**NSIP Reference Name / Code:** EN010120

**Title: Natural England's comments in respect of Drax Bioenergy with Carbon Capture and Storage Project, promoted by Drax Power Limited**

## **Natural England's Written Representations Version 1.1.**

Plate 1-1 - Drawing Showing Location of OHL1 and TCL1

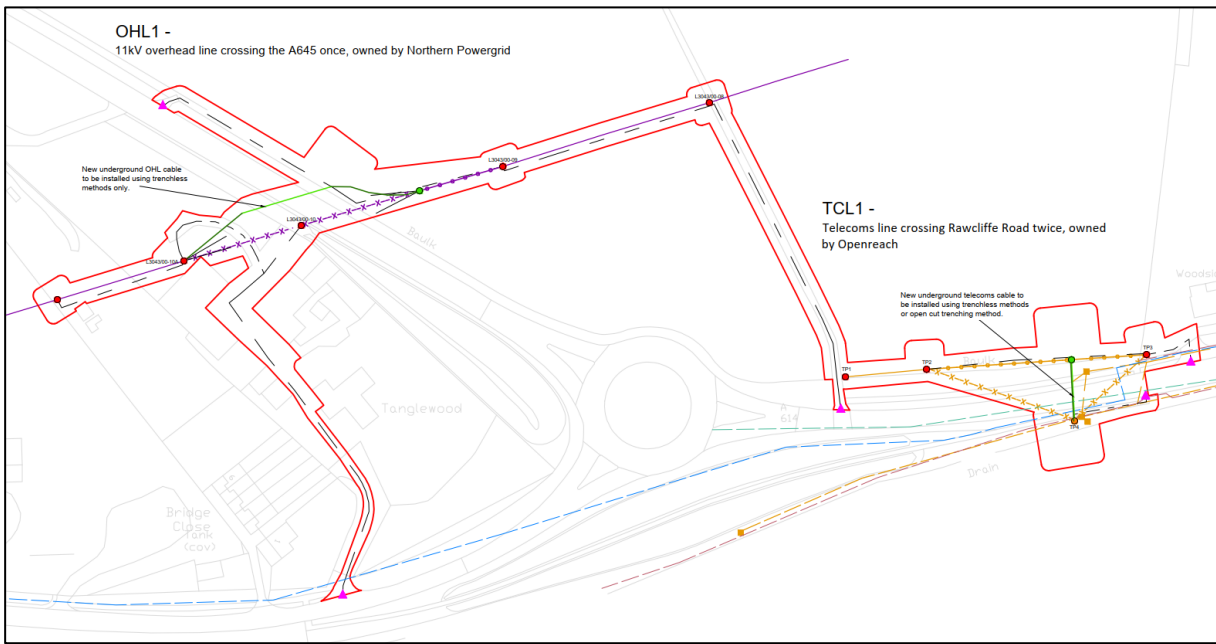
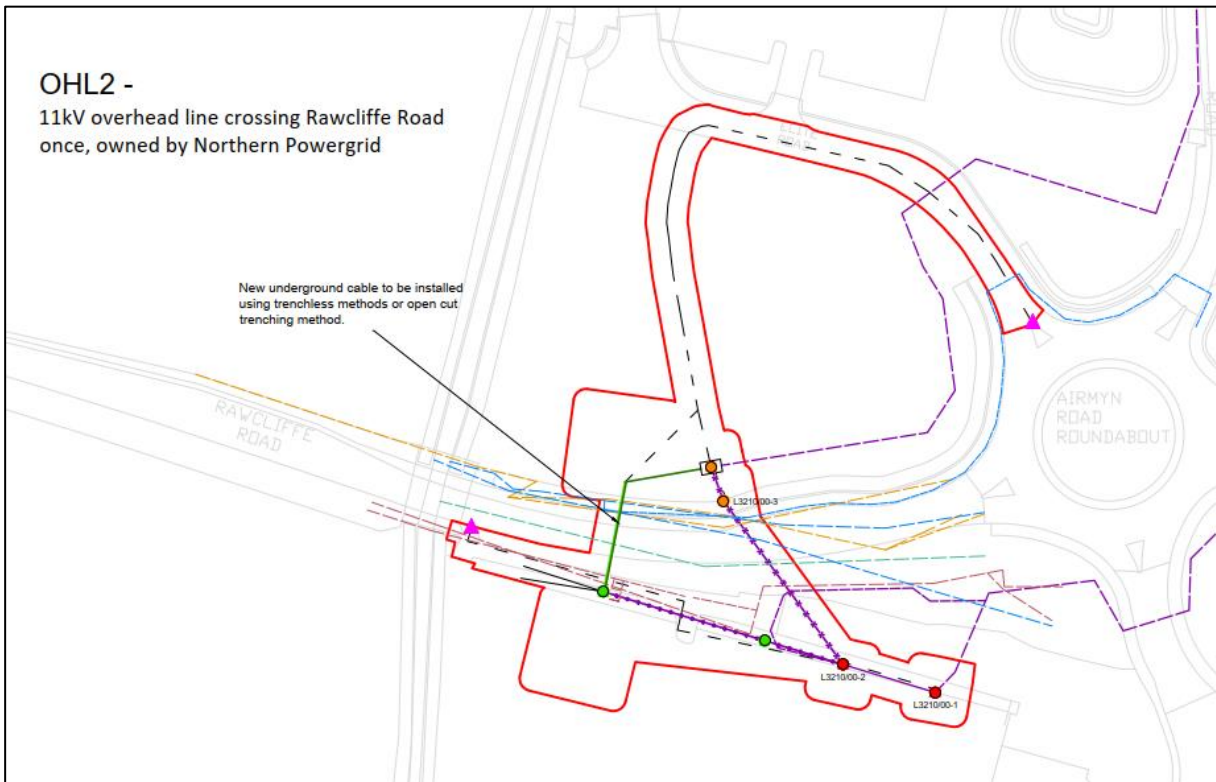
2.1.3.5. Impacts from potential loss of functionally linked land (Construction phase) associated with Humber Estuary SPA/Ramsar in the areas comprising the overhead line (OHL) and Telecommunications line (TCL) Order Limits for Proposed Change 02 (PC-02) ('amber').

2.1.2.5. Impacts from potential loss of functionally linked land (Construction phase) associated with Humber Estuary SSSI in the areas comprising the overhead line (OHL) and Telecommunications line (TCL) Order Limits for Proposed Change 02 (PC-02) ('amber').

DRAWING STATUS			
FOR ISSUE			
DRAWN LH	CHECKED BS	APPROVED MM	AUTHORISED NA
SCALE @ A3 SIZE 1:7,500		DATE 21/04/2022	REVISION P01
DRAWING NUMBER EN010120-PA-ES-6.2.1.3-Sheet1

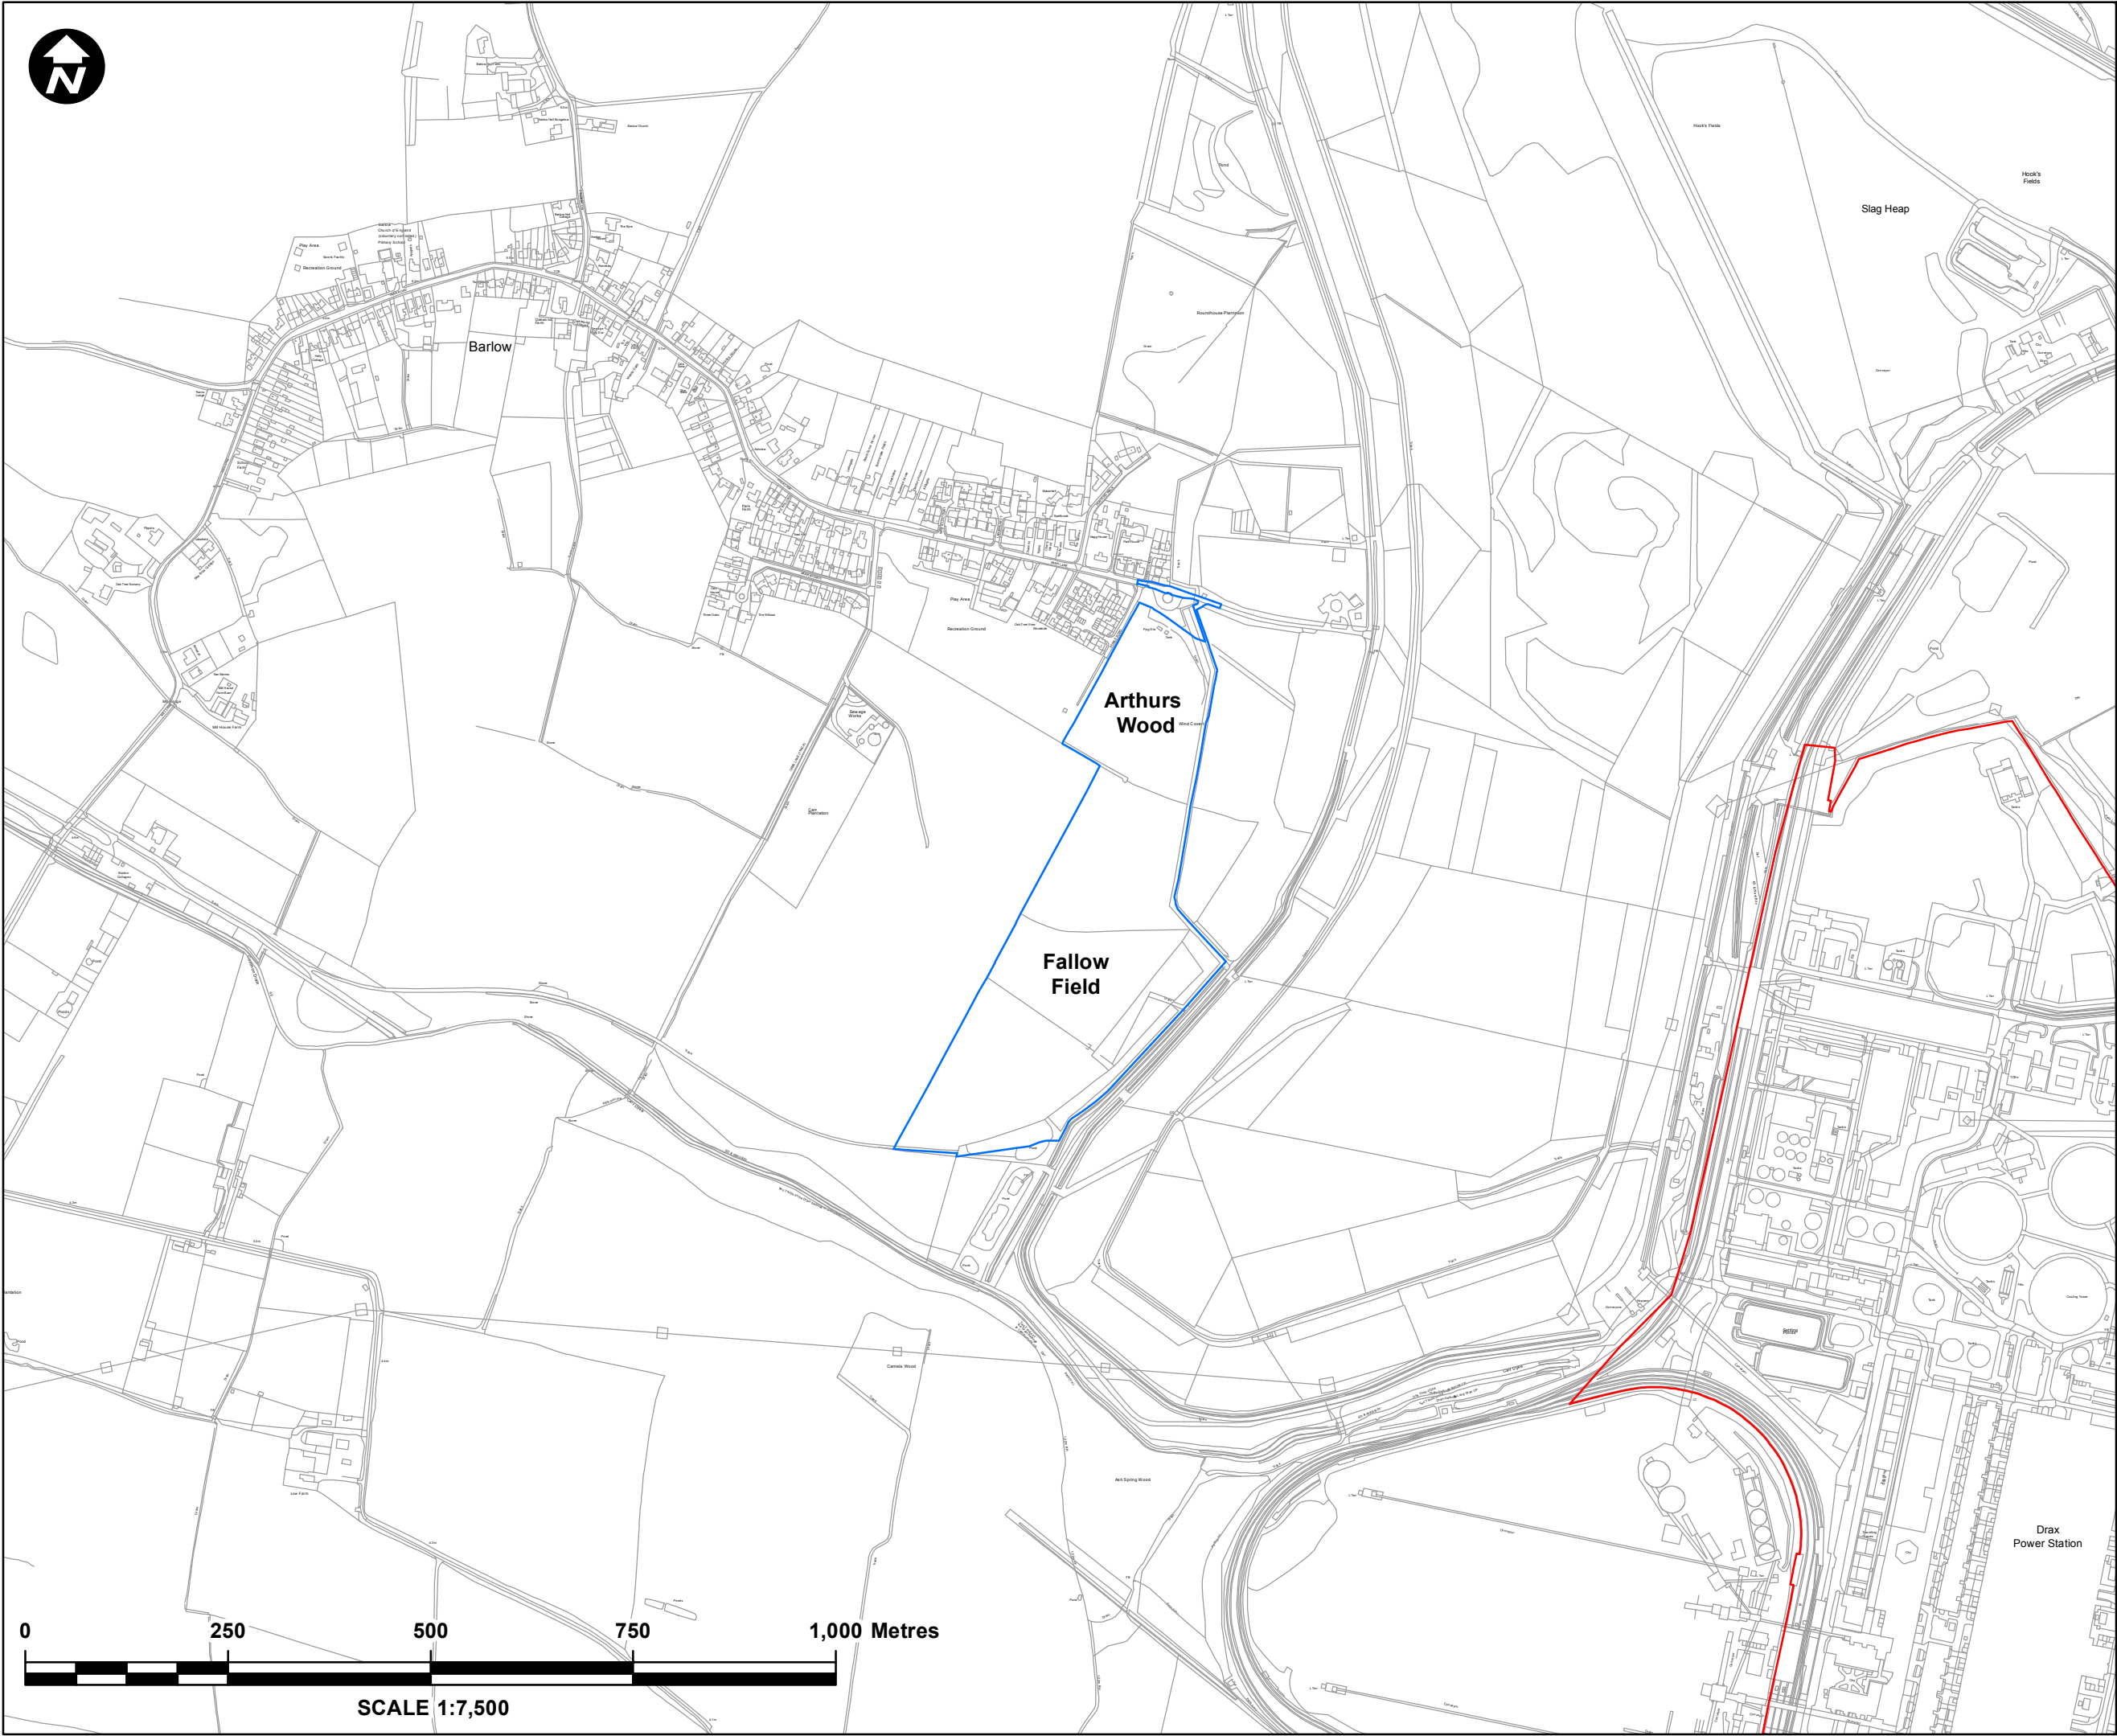
2.1.4.1. Impacts from potential loss of functionally linked land (Construction phase) associated with Humber Estuary SPA/Ramsar and Lower Derwent Valley SPA/Ramsar in the off-site habitat provision area ('green').

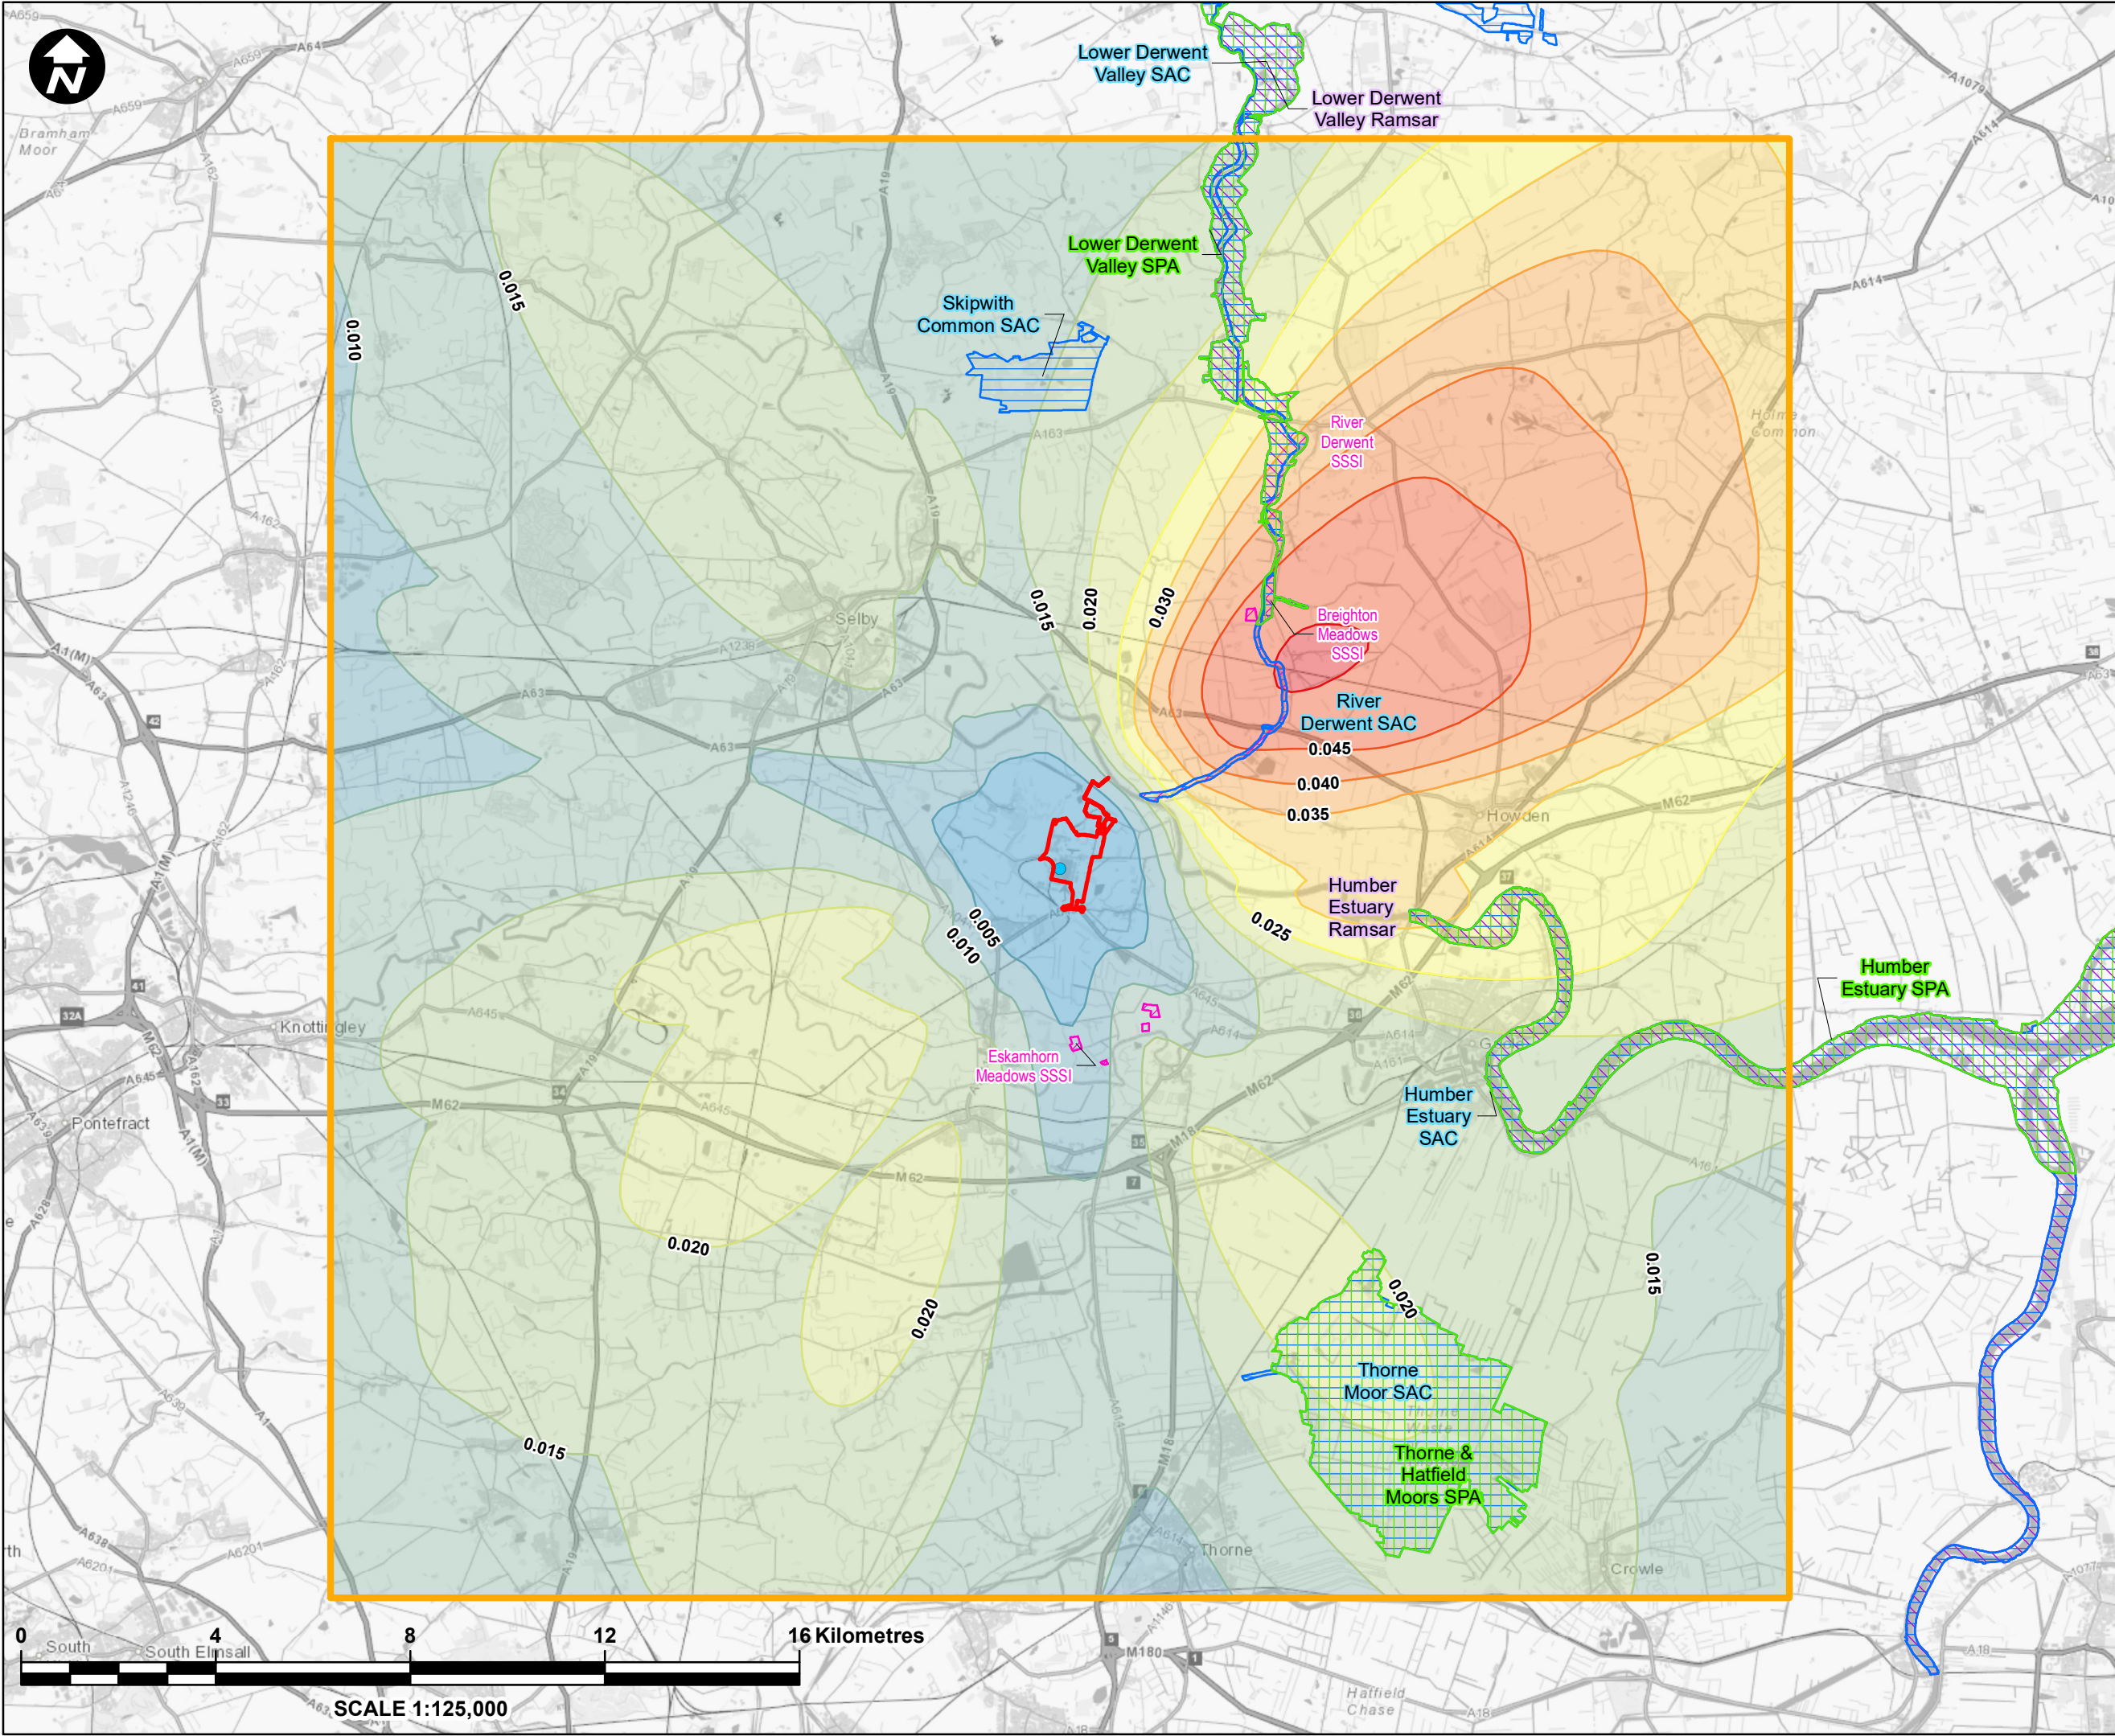
2.1.3.2. Impacts of nitrogen deposition from aerial emissions (Operation phase) on Thorne Moor SAC and River Derwent SAC designated features ('amber').

2.2.2.2. Impacts of nitrogen deposition from aerial emissions (Operation phase) on Thorne, Crowle, and Goole Moors SSSI; and River Derwent SSSI ('amber').

20	<p><b>Internationally designated sites</b></p> <ul style="list-style-type: none"> <li>Thorne Moor SAC</li> <li>River Derwent SAC</li> </ul>	<p>Impacts of nitrogen deposition from aerial emissions on Thorne Moor SAC (in-combination) and River Derwent SAC designated features (alone and in-combination)</p> <p><b>(O)</b></p>	<p><u>Thorne Moor SAC</u></p> <p>At this stage, Natural England’s position broadly remains as set out in our Relevant Representations Version 1.2 (AS-011).</p> <p>Discussions with the Applicant are ongoing on this matter. Natural England are waiting for an updated air quality assessment including additional emissions reductions, which is currently being prepared by the Applicant.</p>	<p>Natural England considers that monitoring, recording and reporting to the regulator (Environment Agency) as part of the future environmental permit is appropriate to ensure emissions from the plant itself remain within the assumed emissions used in the assessments.</p> <p>We recommend that monitoring of the protected sites should also be carried out for nitrogen deposition. This requirement should be secured by the DCO or permit variation</p>	<b>Amber</b>
